ATTACHMENT 2 (A)

Newcastle City Council (NCC) letter 19th October 2017

Document Reference No.: 14002

SITE DIMENSIONING PLAN

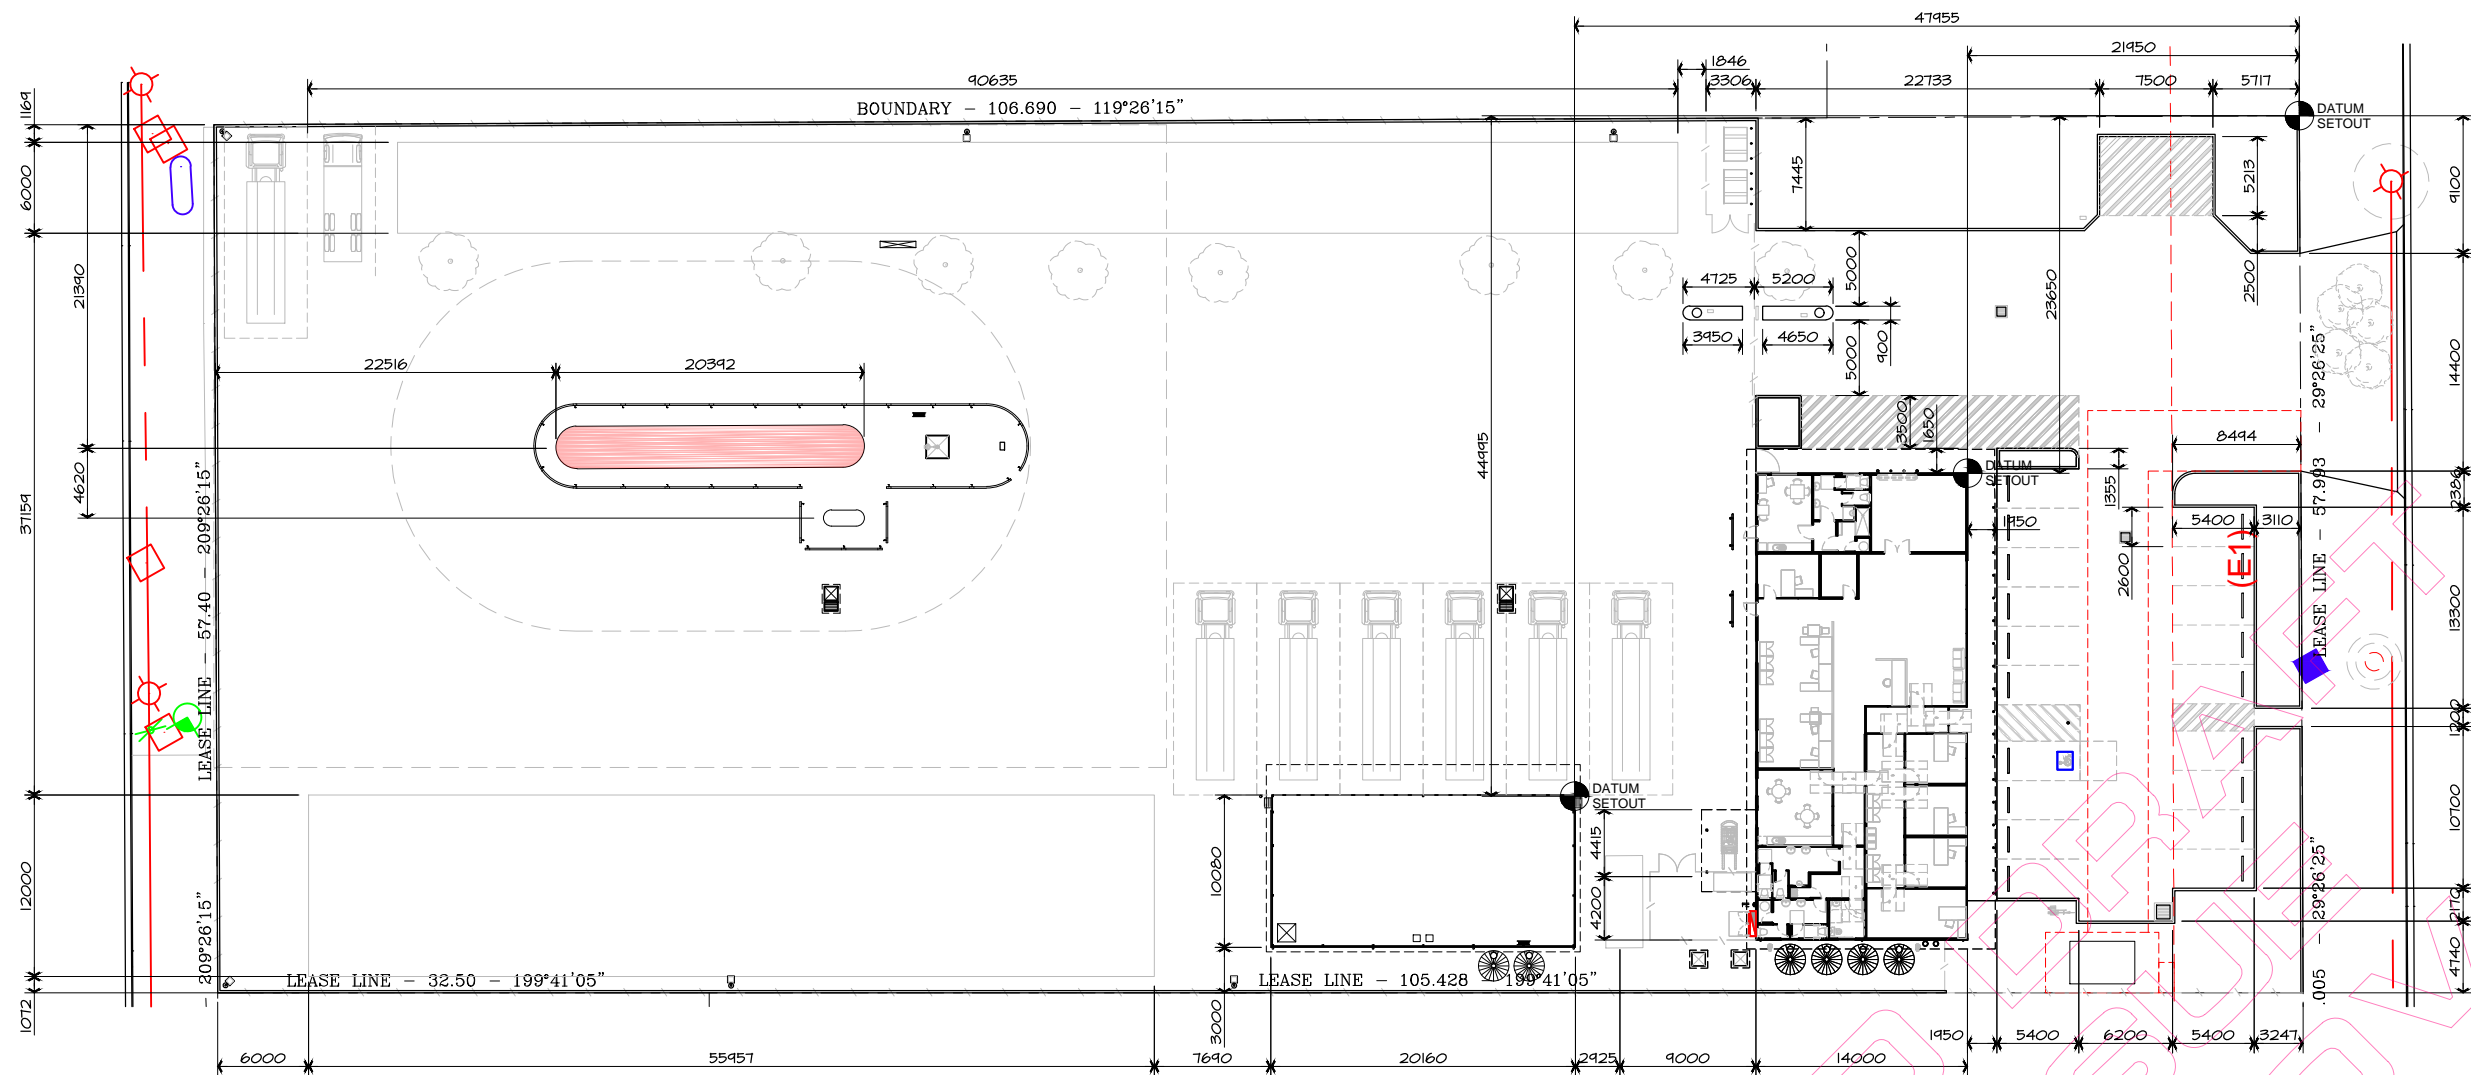
Planning Control No 1 of Section 3.13.04 of DCP 2012 requires a development setback of 5m from the front property boundary. Such setback is to be landscaped and not include any car parking spaces. The objective of the control is to reduce the visual impact of the development on the streetscape and to provide adequate area for landscaping.

The proposal has a variable front setback having a minimum width of 3.1m into which nine car parking spaces partly encroach. It is recommended the design of the development is modified to ensure compliance with the above control.

In terms of development, the Newcastle City Council's DCP does not apply to the land that is the subject of the application (as previously detailed), furthermore the main structure closest to the front of the block (other than the car parking area) is the office building and this is set back 21.9mtrs.

The DCP requires a setback of 5 metres and although the car parking does encroach this setback by just over a metre we are offering a setback distance more than 20 meters to the main building. In this regard and due to the fact, the proposed design offers a setback distance in excess to the main building more than 20 metres, we do not believe the amenity of the area, considering it is a heavy industrial area, is or will be negatively affected.

Project
ELGAS STORAGE FACILITY
Part Lot 1 DP 1145444 - CORMORANT ROAD Cnr. EGRET STREET
KOORAGANG NSW
FOR
SOVECHLES NOMINEES Pty Ltd
Drawing Title
TURNING STUDY - DELIVERY BAY

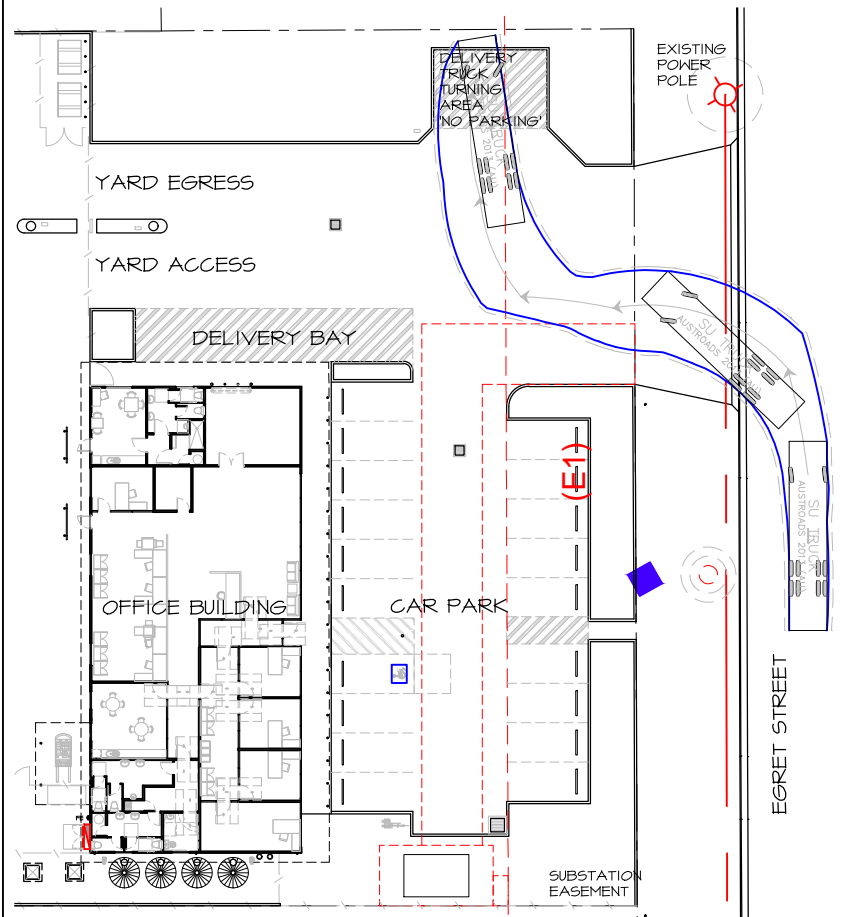
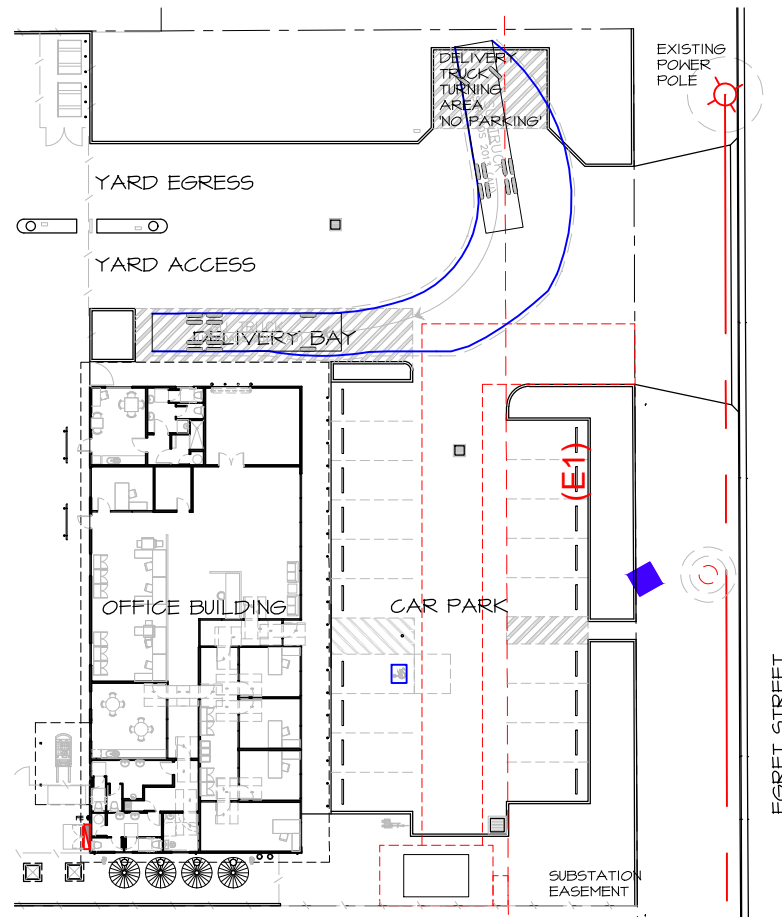
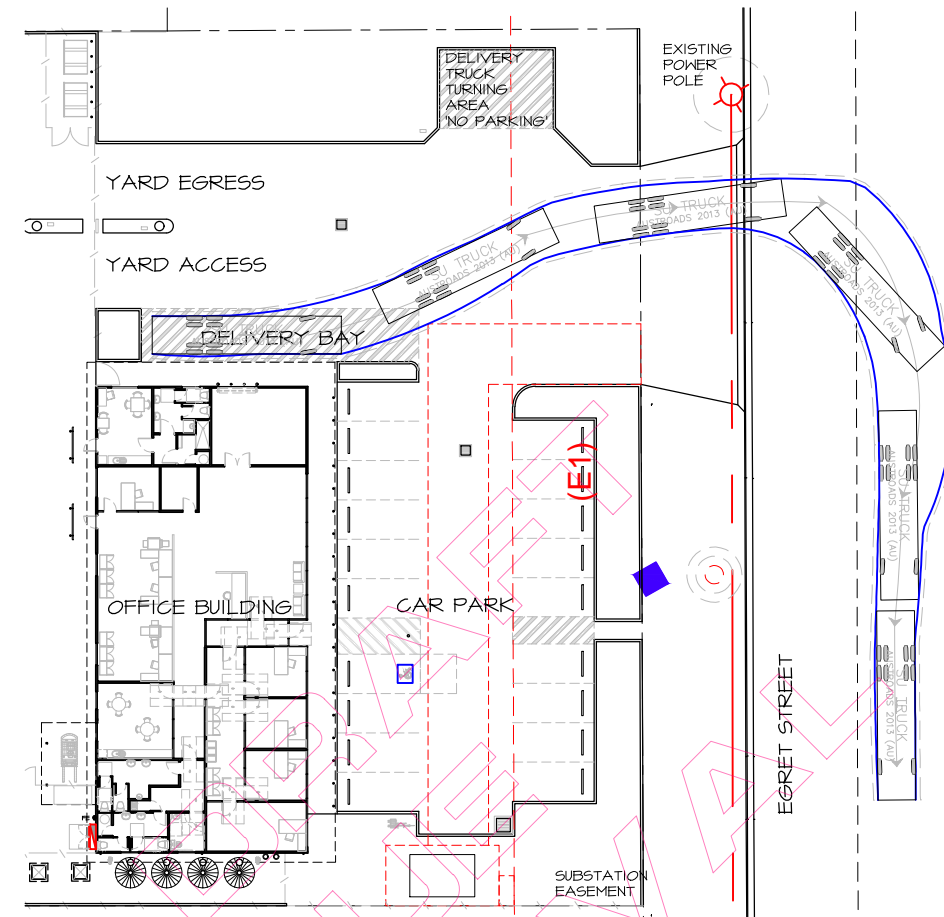
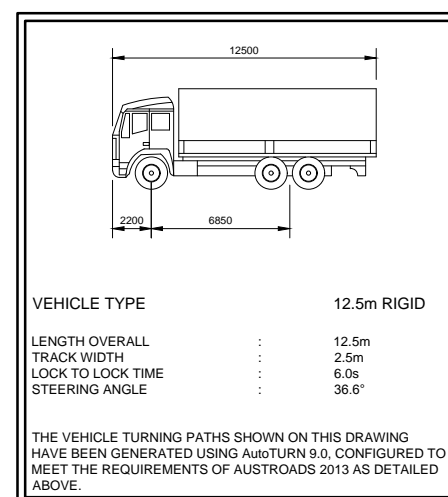
In Council's previous letter concern was raised in relation to the potential for vehicular conflict associated with the operation of the delivery bay due to its proximity to the car park and the site access off Egret Street. The EIS and associated Traffic Impact Statement (TIS) have not satisfactorily responded to the above concern.

It is therefore recommended that the delivery bay be relocated sufficient clear of the car park and site access from Egret Street. This requirement will result in the relocation (setting back) of the gate.

As previously detailed, in Item 4 above, the office building is the closest structure to the front of the block and this is set back 21.9mtrs. The delivery bay referred to in the NCC's comment above is positioned to the north east of the building and this area will only be used for the delivery of general office supplies for the admin building e.g. paper products, office supplies etc. and all other deliveries relating to the main operation will be received at the rear of the site. This access (to the rear of the site) will be controlled by locked security gates and every driver and visitor must be inducted.

The estimated number of deliveries for the front Delivery bay would average less than 1 per day. Furthermore, the area at the rear of the site is a 'controlled environment' due to the hazardous nature of the operation and the request to move the general delivery bay to the rear of the site which would then allow general delivery vehicles and couriers (although very low in numbers) access would be unworkable.

The current plan does not allow access for general delivery vehicles to the rear of the site (as detailed above) the only suitable positioning of the delivery bay is towards the front of the site. The proposed location is also away from the designated car spaces.
